## 2. DENSITY + SCALE

#### 3.1 Little Hay Street alignment

DEVELOPMENT APPLICATION
 ILLUSTRATIVE SCHEME
 SOUTH ELEVATION
 FROM LITTLE HAY STREET

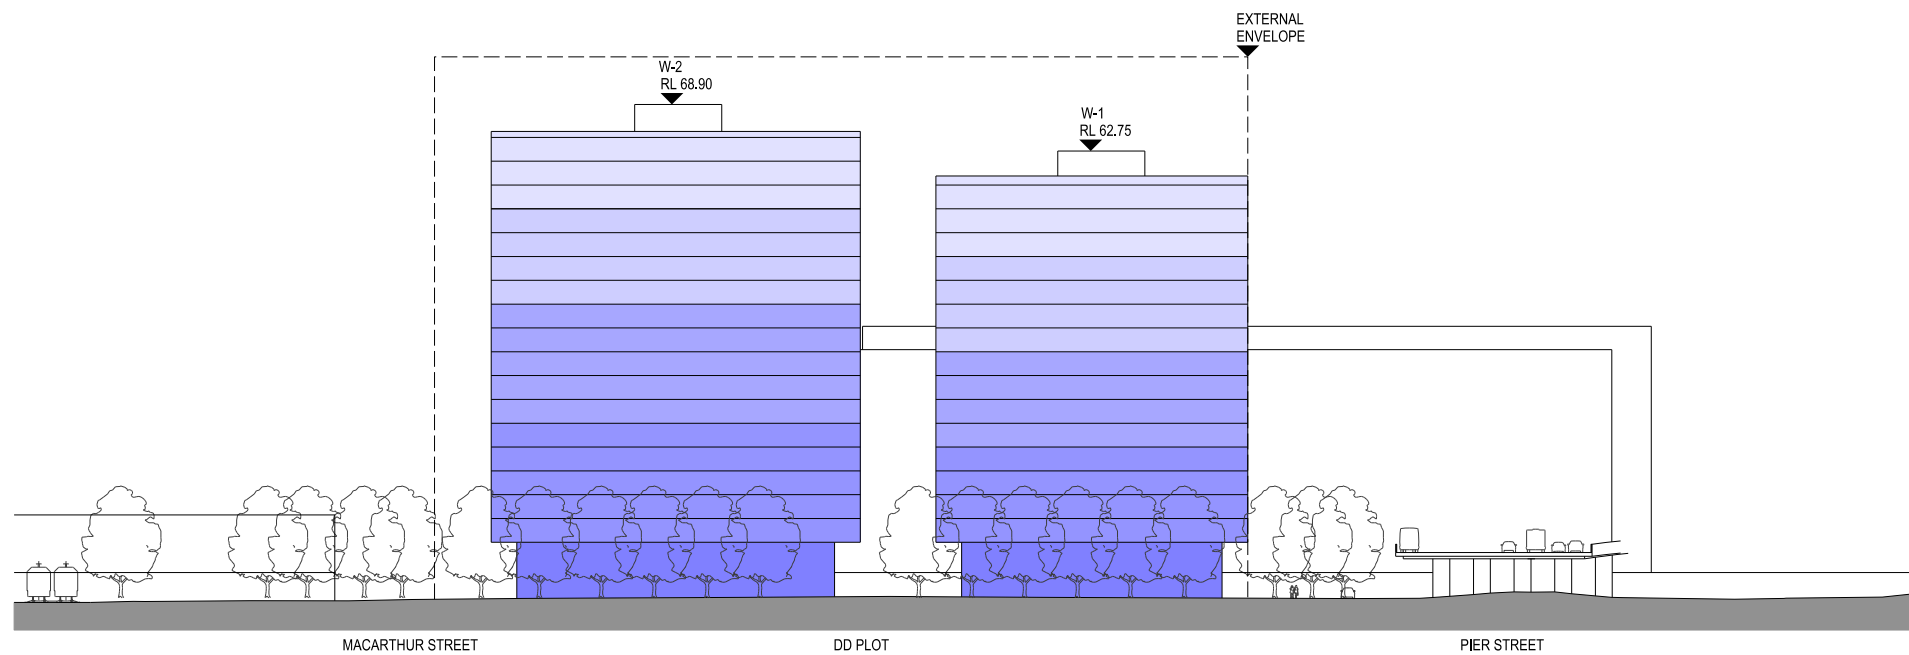
The key block planning concepts are generally supported with qualifications. The southern precinct must be an extension and resolution of the urban form, block patterns and character of Chinatown and Ultimo. The new square acts as the point of block patterns resolution. Little Hay Street is an important connector from Sussex Street and should be continued on its linear axis. Little Hay Street could also encourage visitors travelling south along the Boulevard to move east into Chinatown by virtue of a splayed building alignment on the northern side.

Connectivity into wider urban context, including Chinatown, has been a key consideration of the Concept Proposal.

Continuity of street widths, grain of ground level retail uses and a consistency of landscape design and palette are all proposed to achieve a seamless integrated piece of city.

The existing Little Hay Street alignment conflicts with the geometry of the predominant local street pattern.

The Concept Proposal's continuation of Little Hay Street adopts this predominant grid; parallel to the adjacent Hay Street and Factory Lane— refer Hay Street (potential) market section of this report.
